24 October 2016

Eagleton Rock Syndicate Pty Ltd  
PO Box 898  
Newcastle 2300

## **Groundwater Assessment Peer Review**

Umwelt. Eagleton Hard Rock Quarry: Water Assessment, prepared for Eagleton Rock Syndicate Pty Ltd. October 2016.

Figure 4 Private registered groundwater bores within 5 km radius from the Project Area

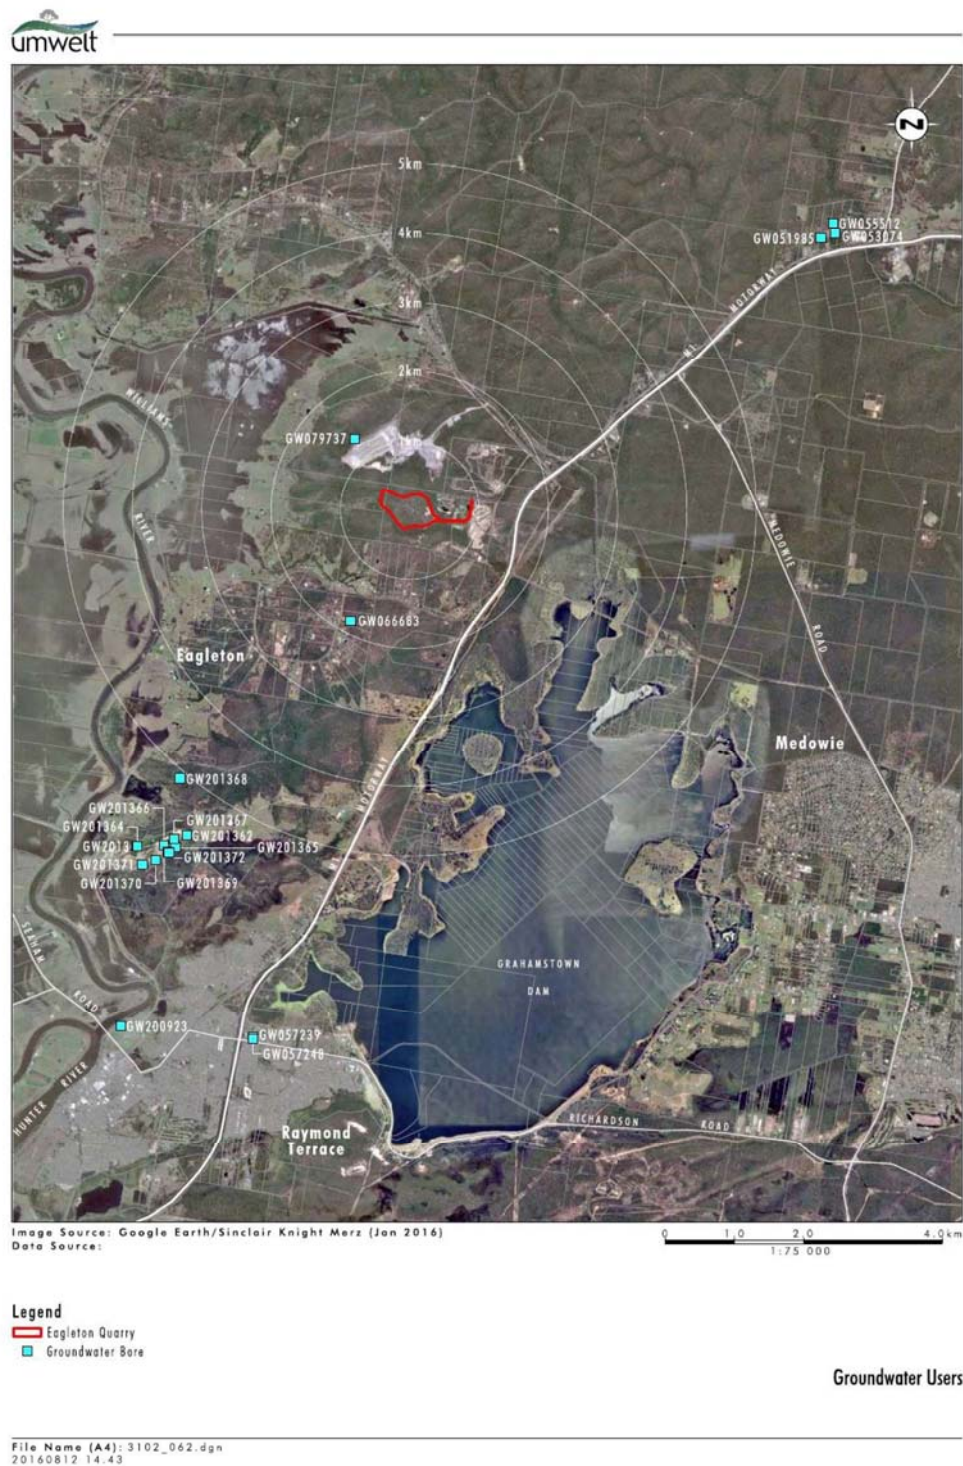
- Table 4.1 – the response column that directs the reader to the sections where the issues are addressed should be updated.
- Section 4.2, pg 58, second paragraph, first sentence – The first sentence refers the reader to Figure 3 of Appendix 1a. I believe this should be Figure 4 of Appendix 1a.

- Section 4.2, last sentence – there appears to be a font size issue in text.
- Section 6.1.1 - The first sentence refers the reader to Figure 3 of Appendix 1a. I believe this should be Figure 4 of Appendix 1a.

Figure 7 Groundwater model boundary conditions

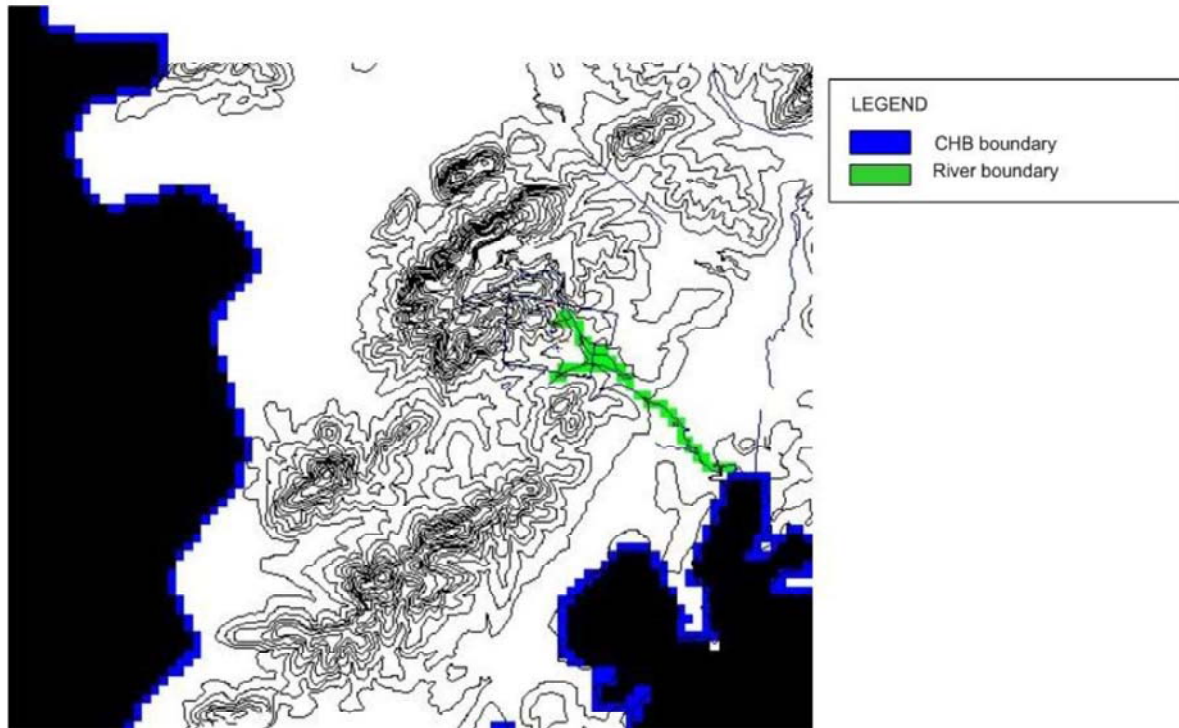
- Section 6.1.2, pg 79 - The first sentence refers the reader to Figure 5 of Appendix 1a. I believe this should be Figure 7 of Appendix 1a.
- Section 6.1.2, pg 79, second paragraph - The first sentence refers the reader to Figure 16 of Appendix 1a. I believe this should be Figure 22 of Appendix 1a.

Figure 15 Groundwater heads in relation to Project Area boundary in Layer 1 at the end of Year 6

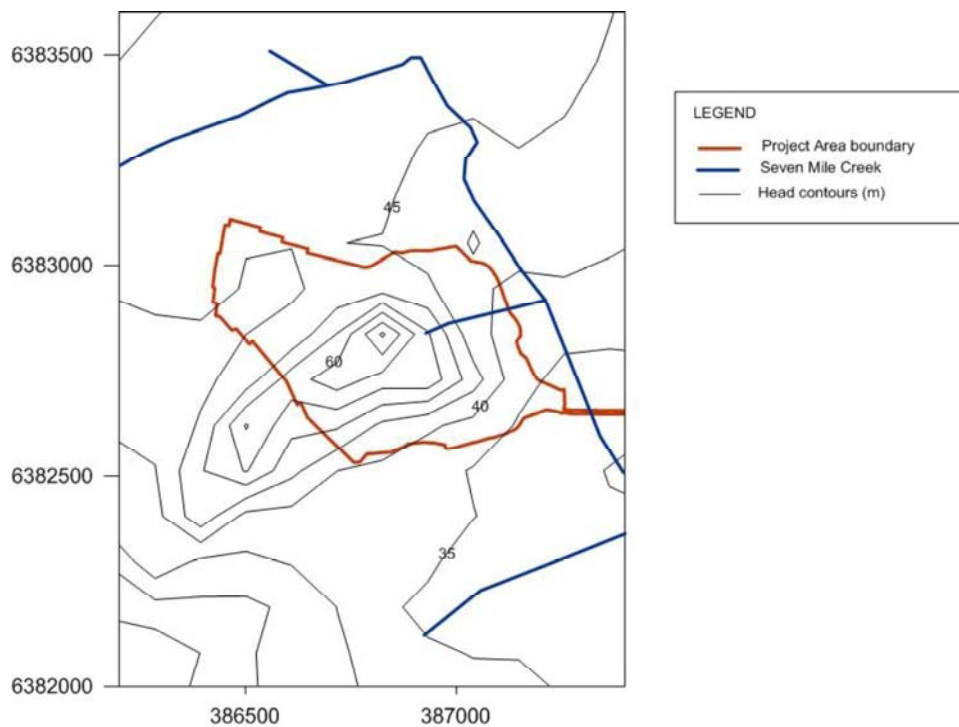
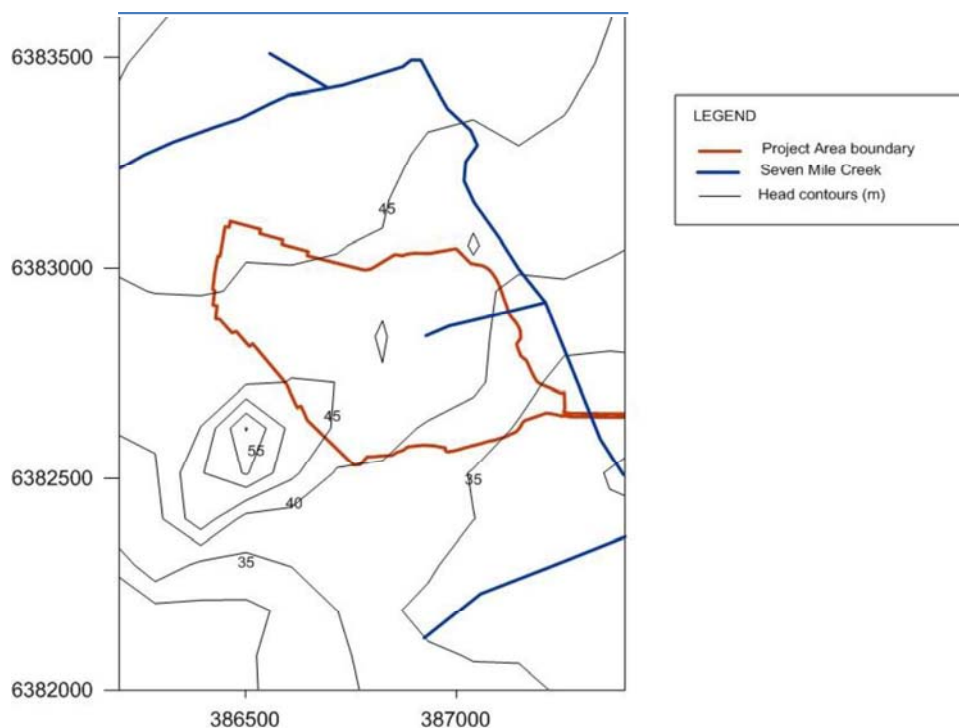
- Section 6.1 – this section would benefit from a summary of the impact assessment according to the NSW AIP previously assessed in section 4.4.
- Appendix 1a, Figures 15 and 16 – The figures and supporting text refer to groundwater head. Head is a measurement with reference to specific datum, typically a measurement of head pressure above a datum. It is assumed that the values presented are actually water levels in m AHD but this is not clear.
